Our Ref: EN010154

## The Infrastructure Planning (Examination Procedure) Rules 2010 – rule 17

### Application by Fosse Green Energy Limited for an order granting development consent for the Fosse Green Energy

#### Request for further information

FIGURE TITLE
400KV PIPELINE CROSSING
FIGURE NUMBER
Figure 1-1
DOCUMENT REFERENCE
EN010154/APP/X.X

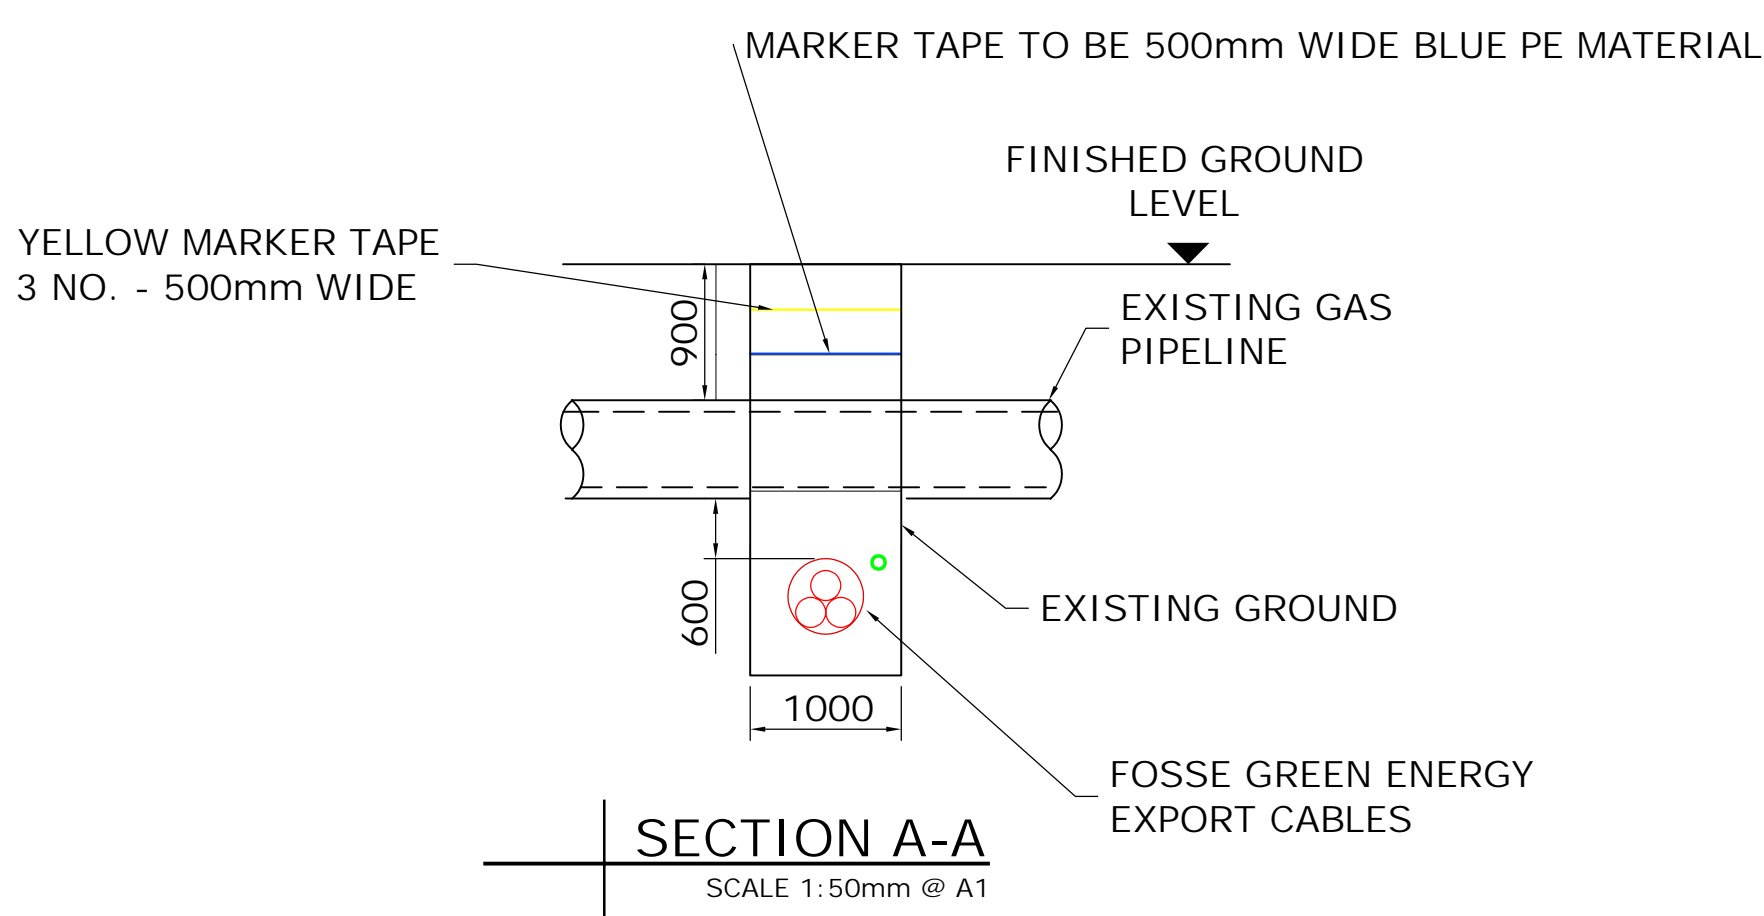
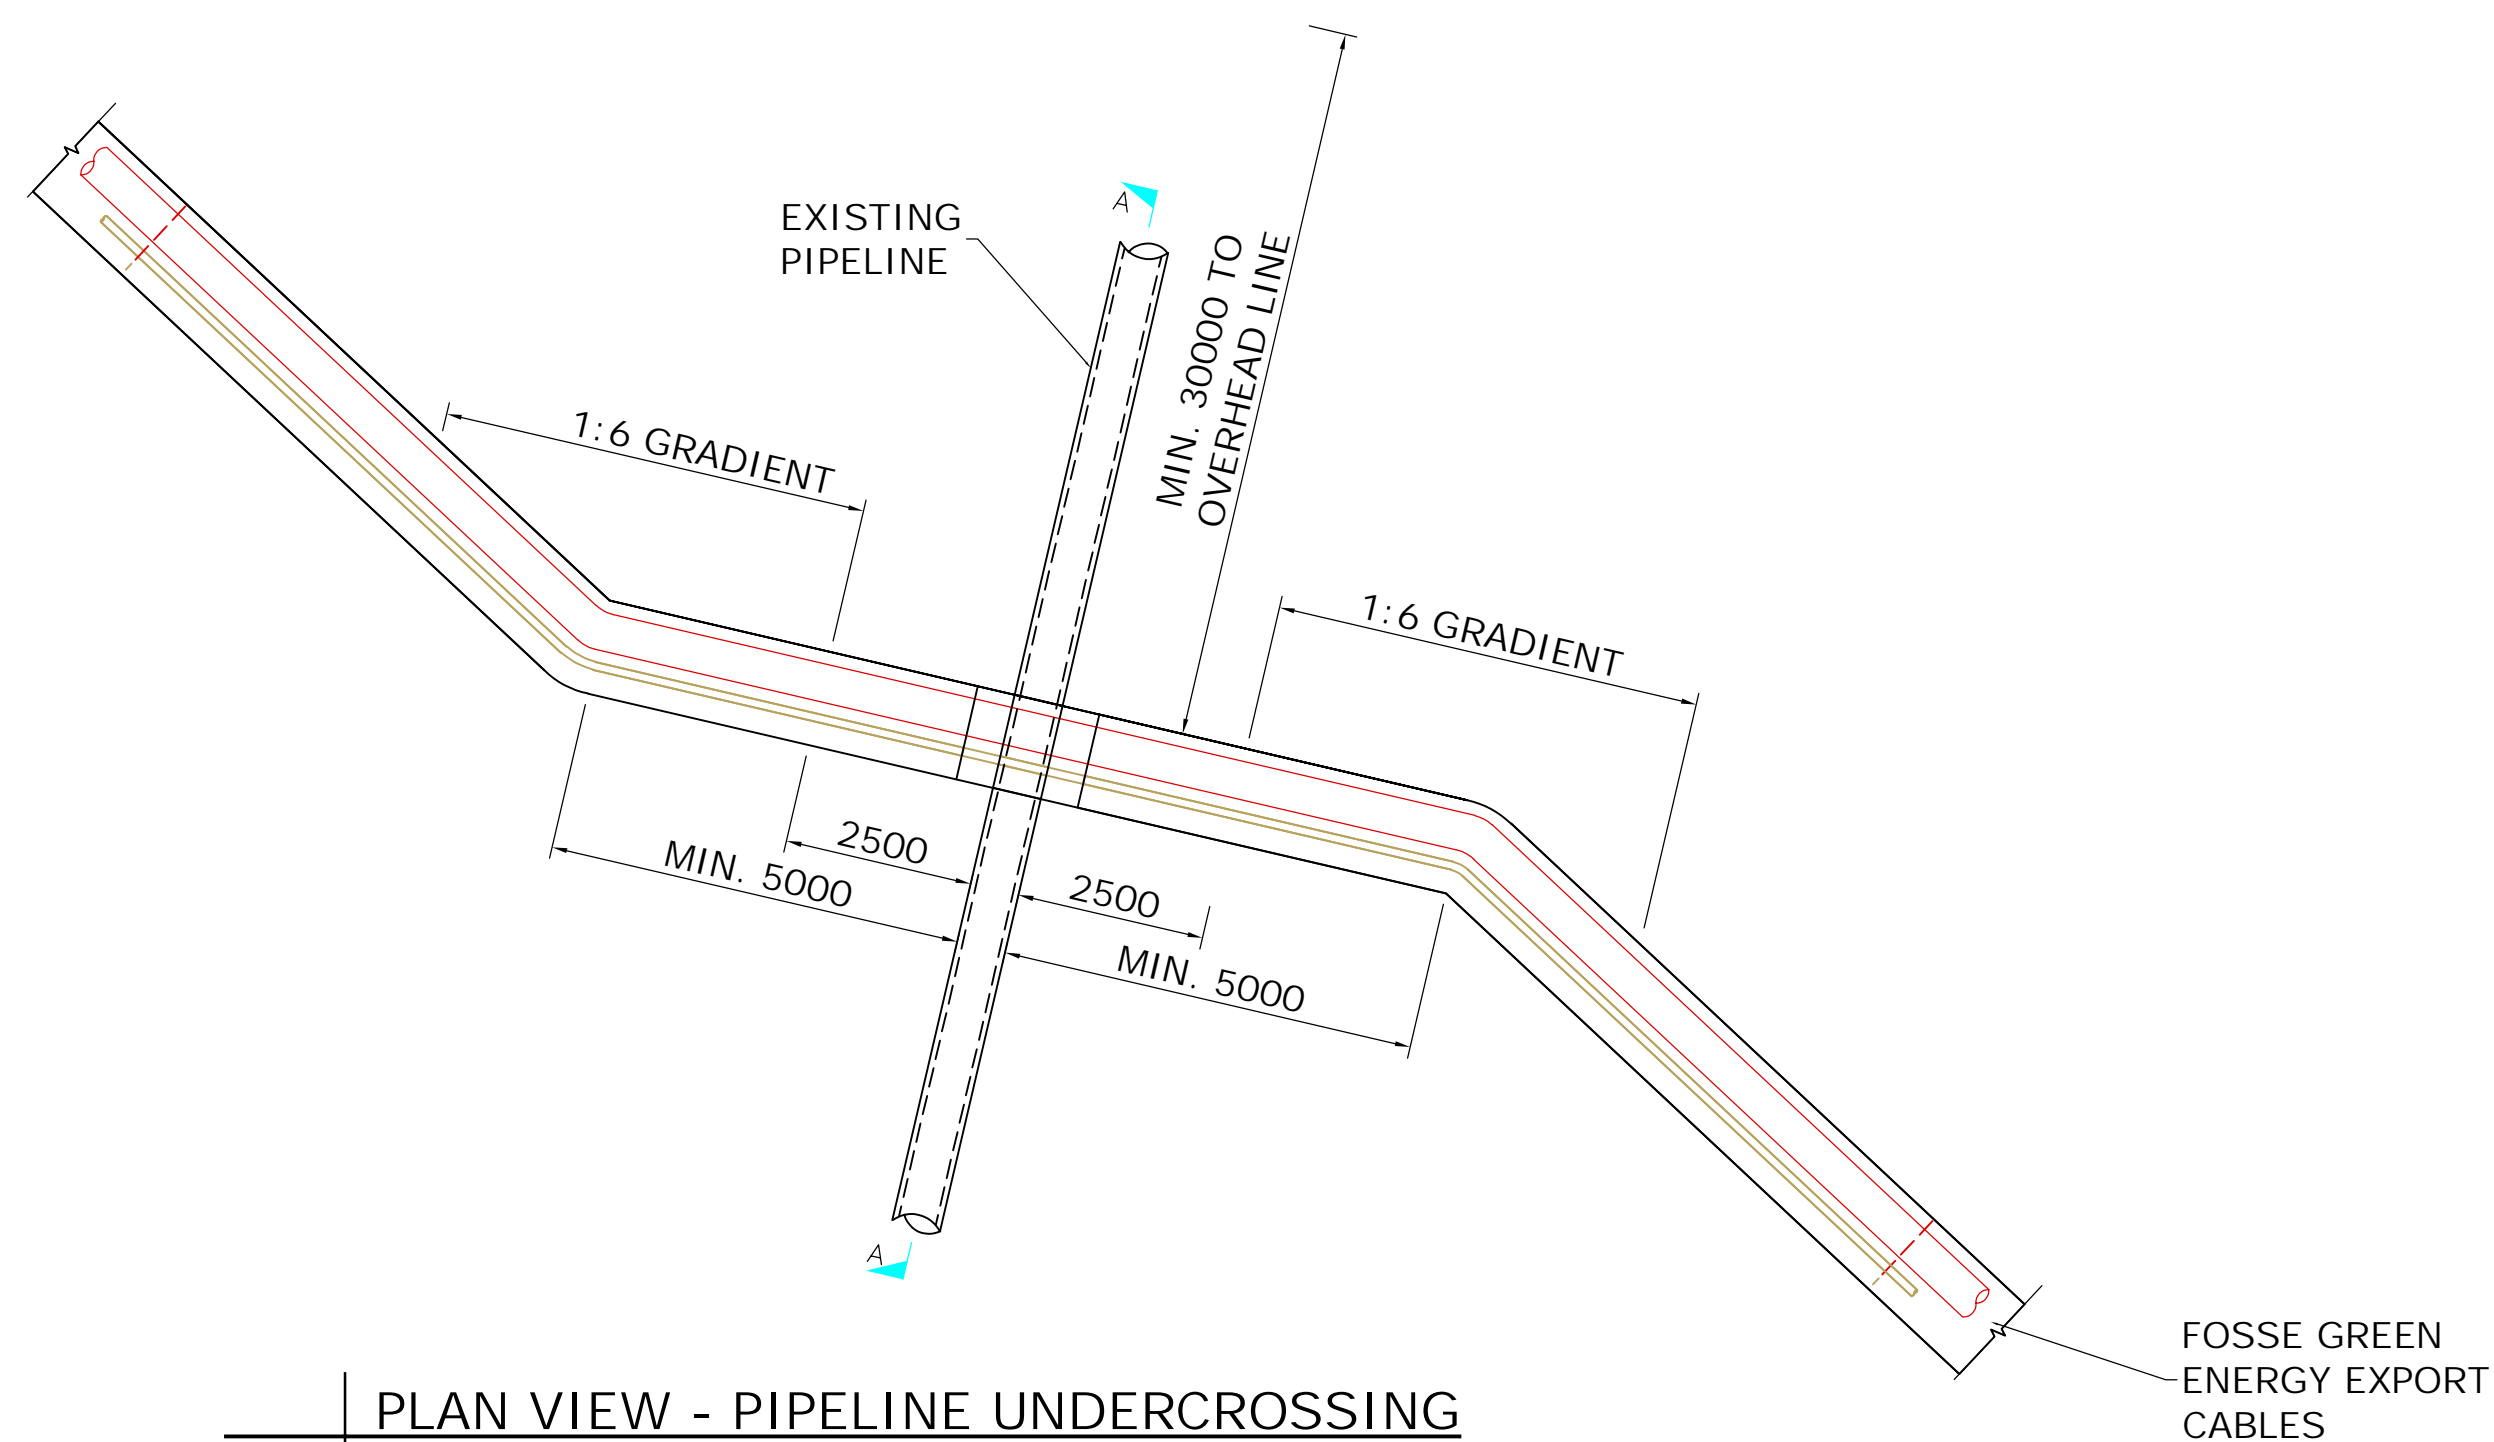
- 1) **Applicant and Prax** - a sketch drawing (or drawings) and/or a technical specification demonstrating how the pipeline could be crossed in a safe manner that accords with all of the relevant legislation and/or guidance. In preparing and submitting that information a worst case safety case should be assumed and the parties should ensure that the other party has sufficient information available to it to complete this task.
- 2) **Applicant** - a copy of the updated modelling report referred to in [\[REP4-018\]](#).
- 3) **Applicant and Prax** – the outstanding final and signed SoCG, including a set of bespoke protective provisions showing agreed and any disagreed text. With respect to the protective provisions in the event of there being any disagreement, the reasons for any such disagreement must also be provided.
